27 June 2019

File No: R/2018/30/A  
Our Ref: 2019/317266

**Concept Stage 1 State Significant Development - 301 and 305 Kent Street Concept Hotel Development (SSD 9694)**

Lower Ground Level

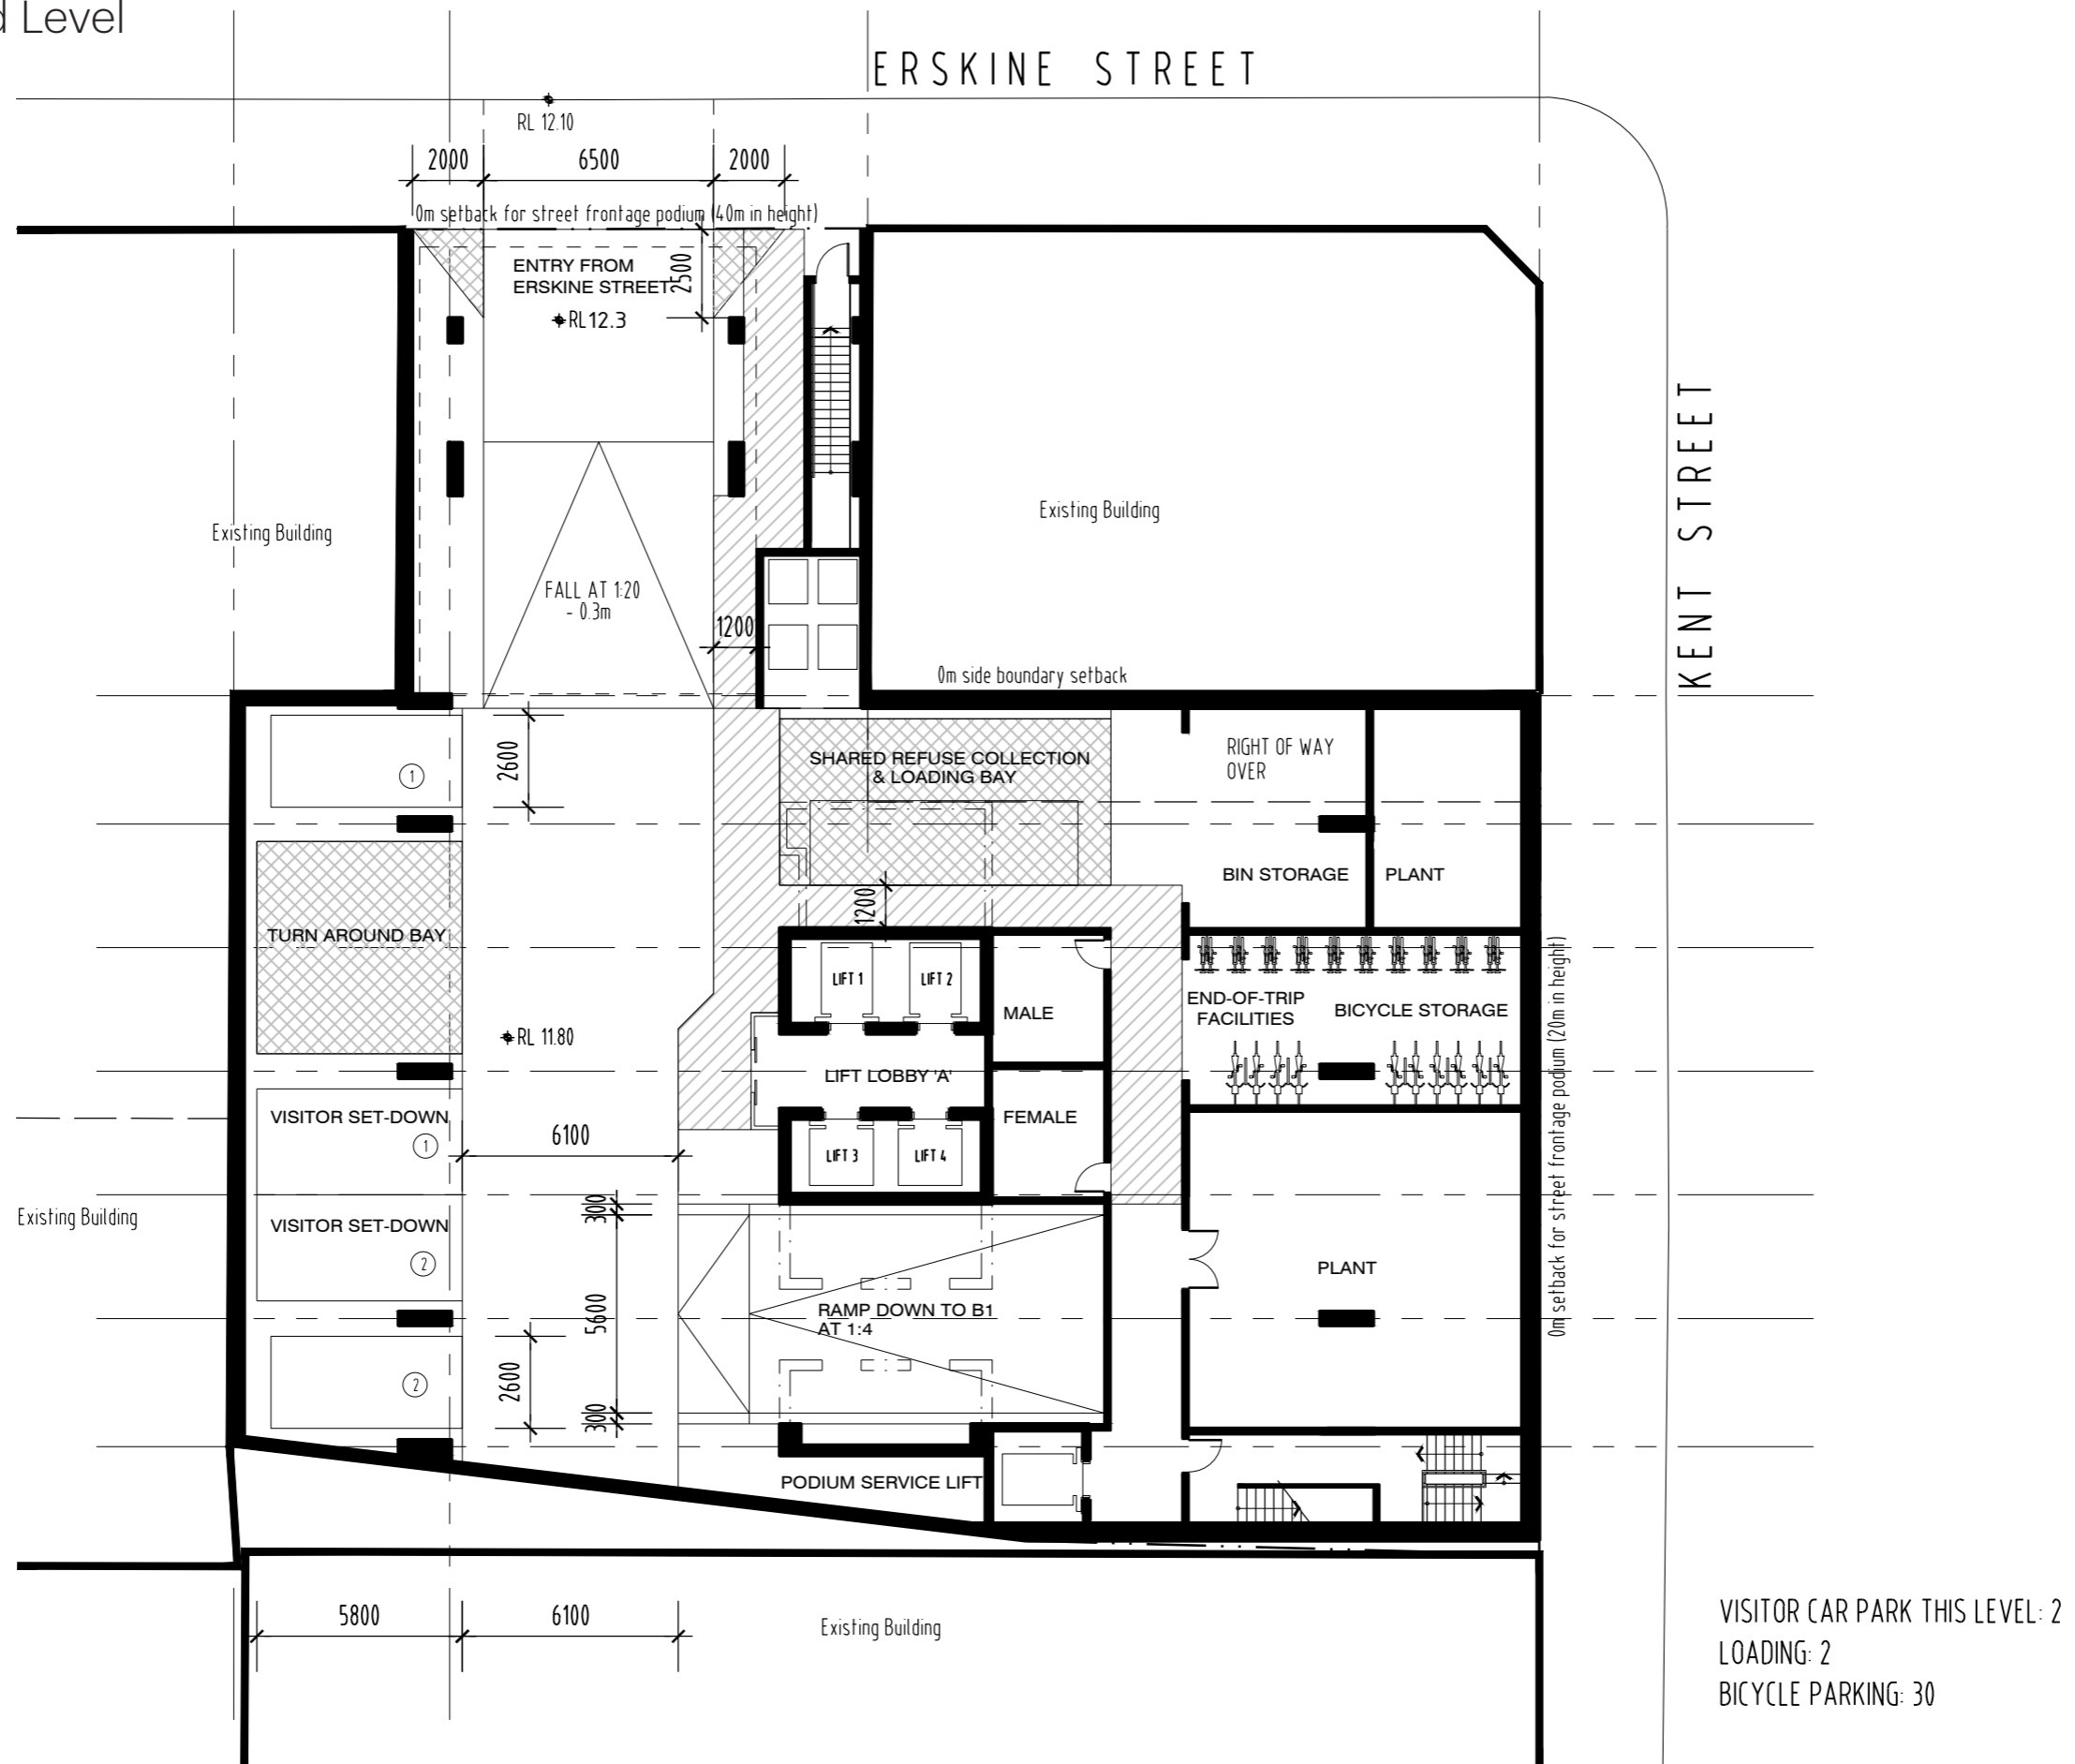
The Architectural drawings includes detailed floor plans and sections, including basement, ground floor, hotel room layout plans etc. and a development matrix.

While these plans are necessary to assess how the concept scheme may work, they should not be included in the approved set of plans. This is to ensure that during the competitive process, architects are not unduly influenced or fettered in developing a creative and innovative design solution for the site. The approved plans should be limited to envelope plans only (detailed architectural plans should not be referenced for approval).

Podium Section CC

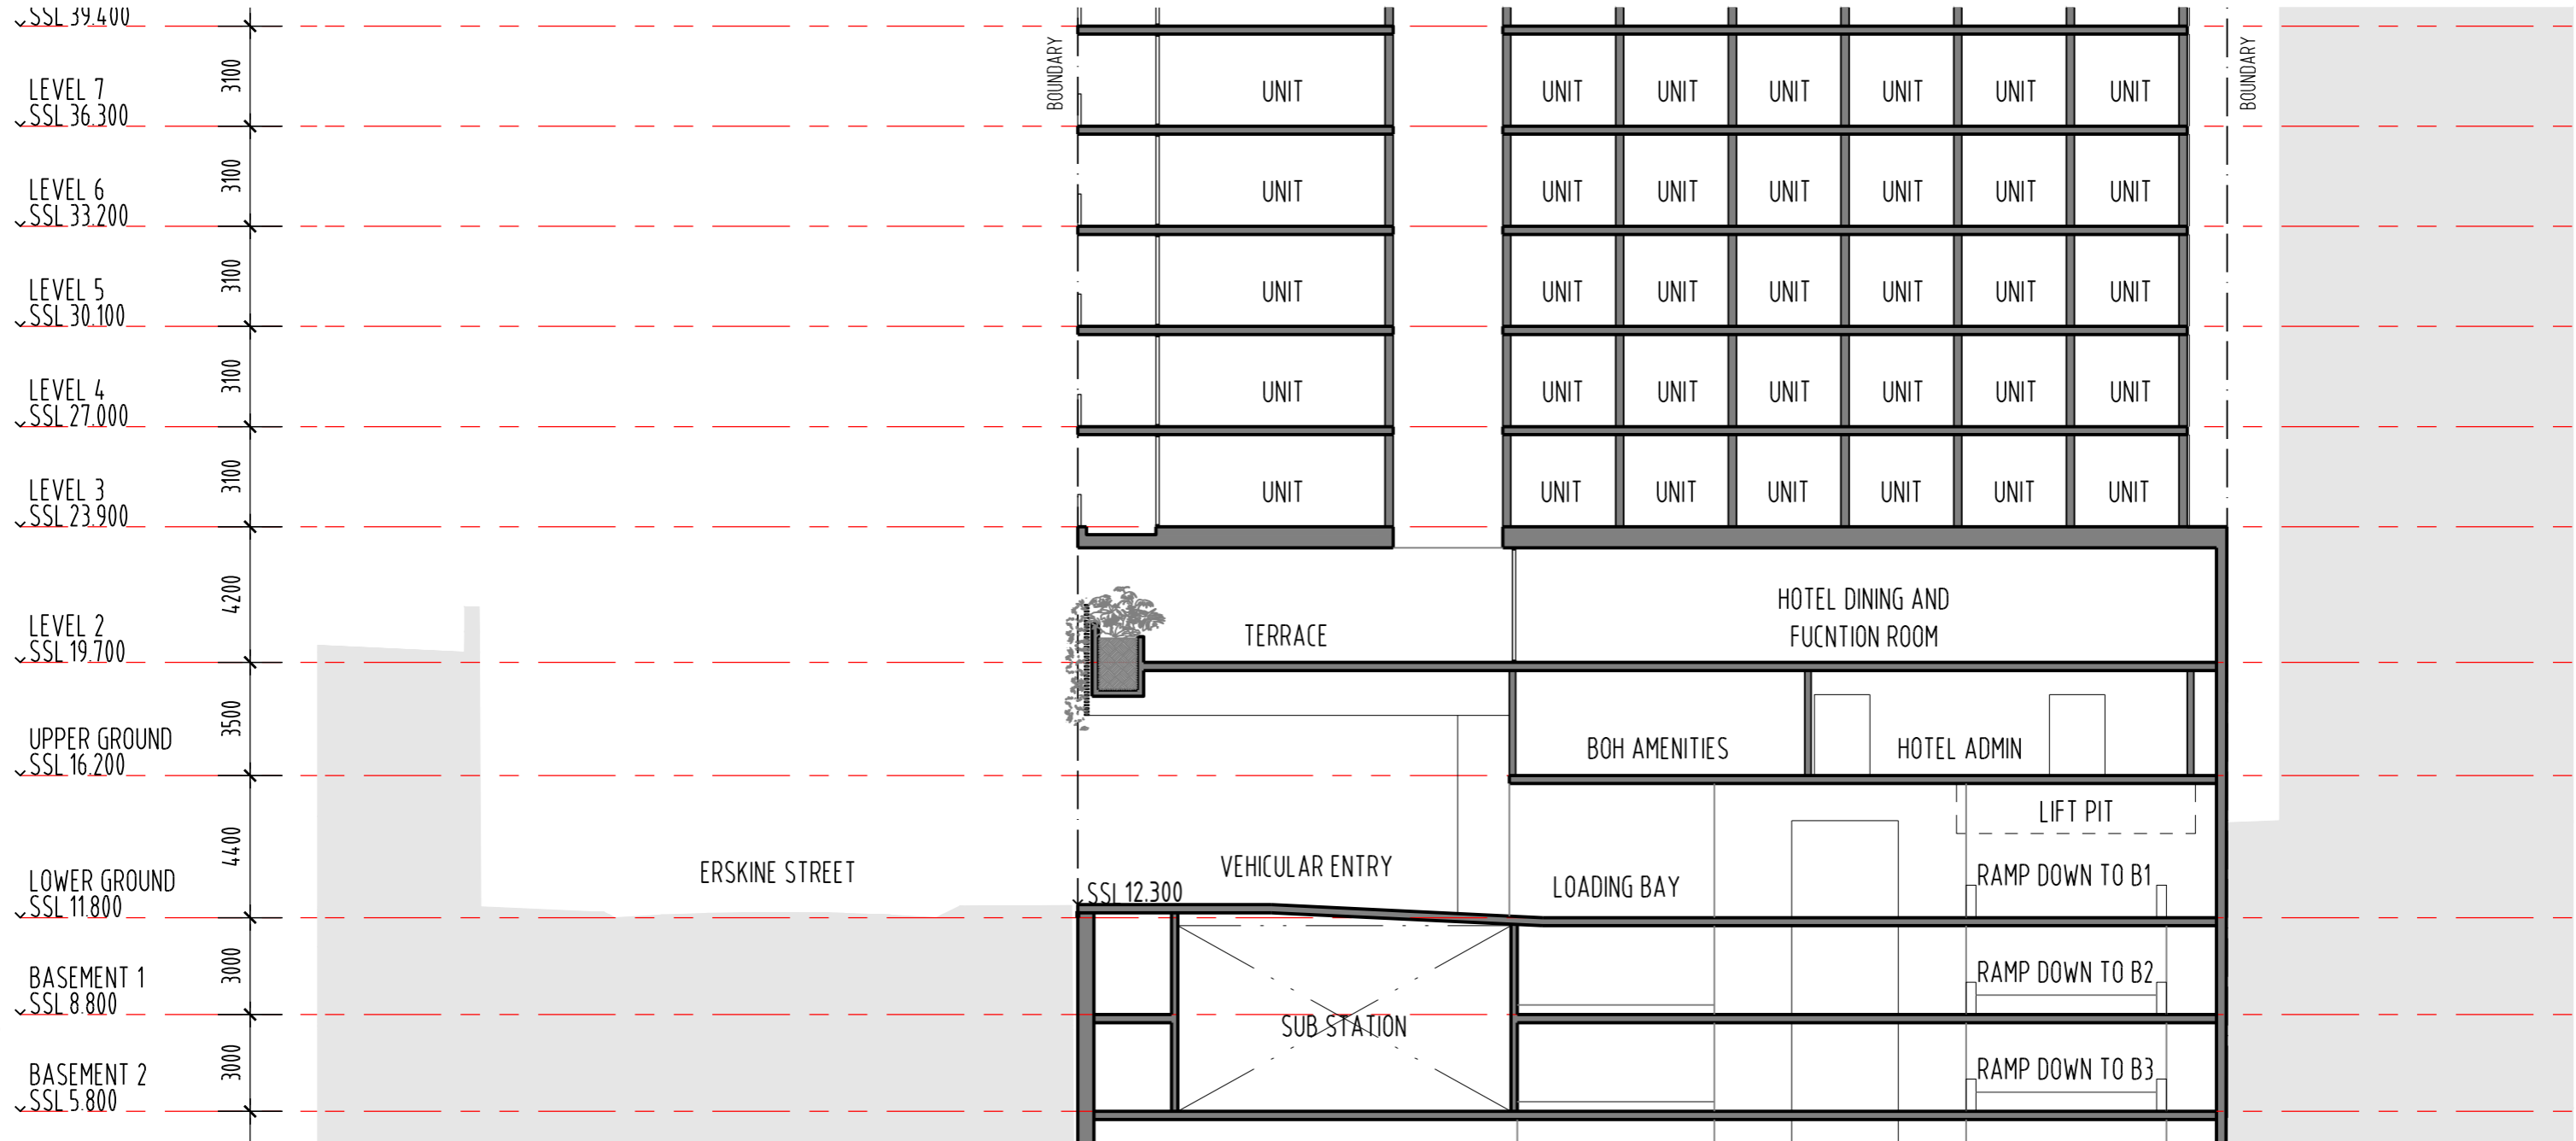
The Stormwater Design Management Report nominates a basement carpark ramp threshold of RL12.3m AHD. It is noted that this has not been reflected on the concept

architectural drawings. The north elevation and podium section CC plans both show a vehicle entry RL of 12.2m.

- Basement entry crest shall be set as a minimum at 300 mm above the adjacent road gutter invert and
- Hotel reception shall be set as a minimum at 300 mm above the adjacent road gutter invert.
